**Ref – Planning application for 43 Waddow View 3/2021/1195**

Waddington Parish Council has considered planning application 3/2021/1195 and has the following comments.

EXISTING SITE BLOCK PLAN

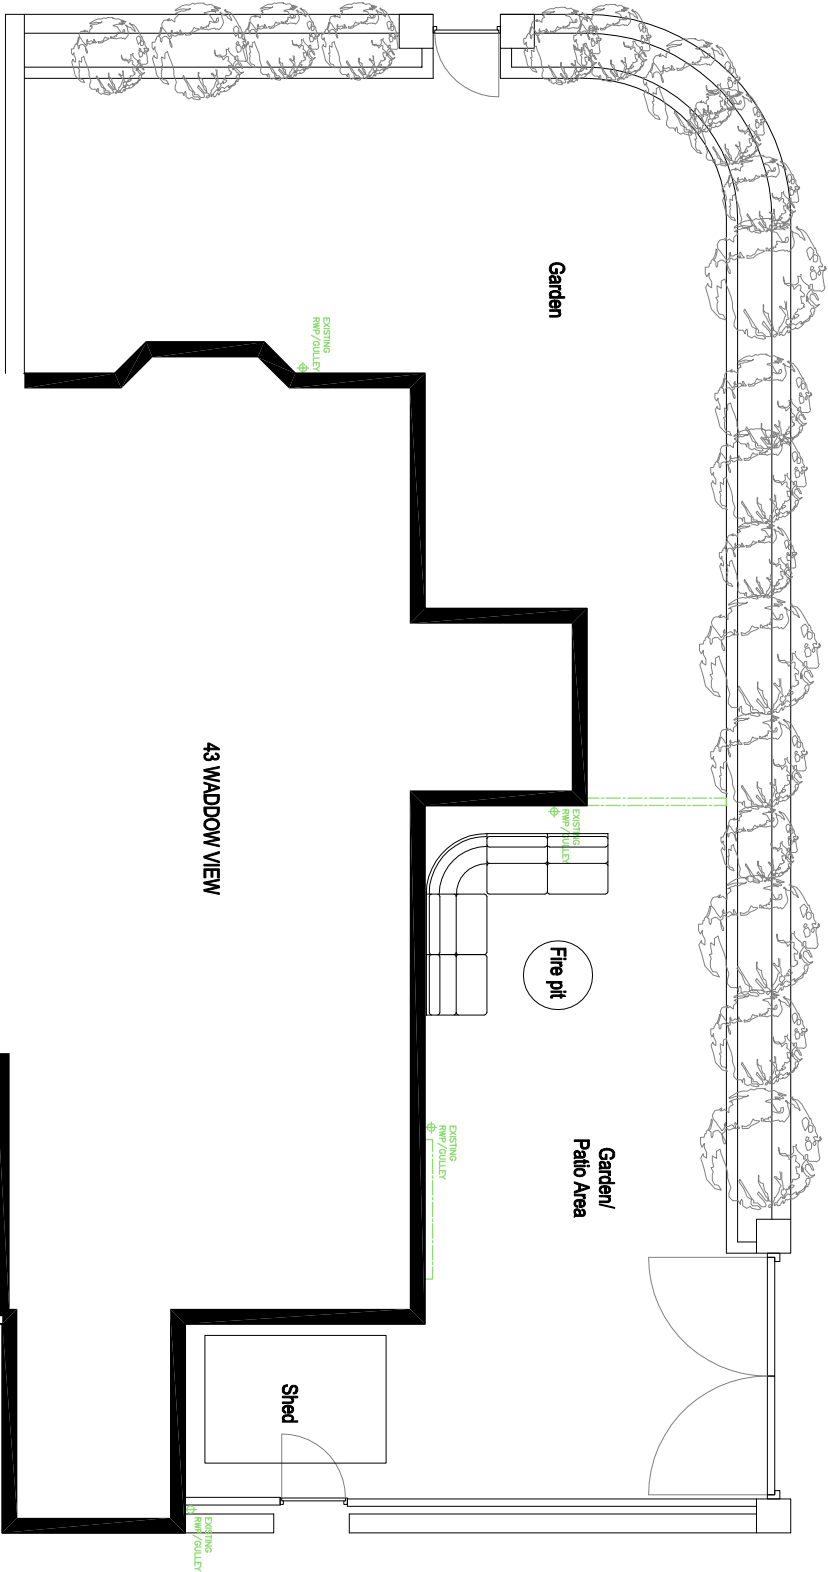
The planning application will remove off road parking, and potentially remove the requirement for the vehicular bridge that was part of the planning application in 2005 (3/2005/0908).

In 2005 the planning application, submitted by previous owners, (referred to in the consultation response from LCC Highways), to provide a vehicular crossing/bridge over the brook was not carried out as detailed in that planning application 3/2005/0908. The bridge was supposed to have rails on either side of it, to allow flood water to pass over the bridge and flow away from the properties. Instead, low level walls were built (see photo below) which increased the risk of flooding to nearby properties and in November 2020 this amended feature caused flooding to nearby properties.

1. As the planning application removes the off-road parking at the property the bridge should be removed to reduce the risk of future flooding.
2. If the bridge is to remain the walls need to be removed/replaced with railings to reduce the flood risk to nearby properties.
3. Request this matter is further investigated by LCC Land Drainage and the Environment Agency.
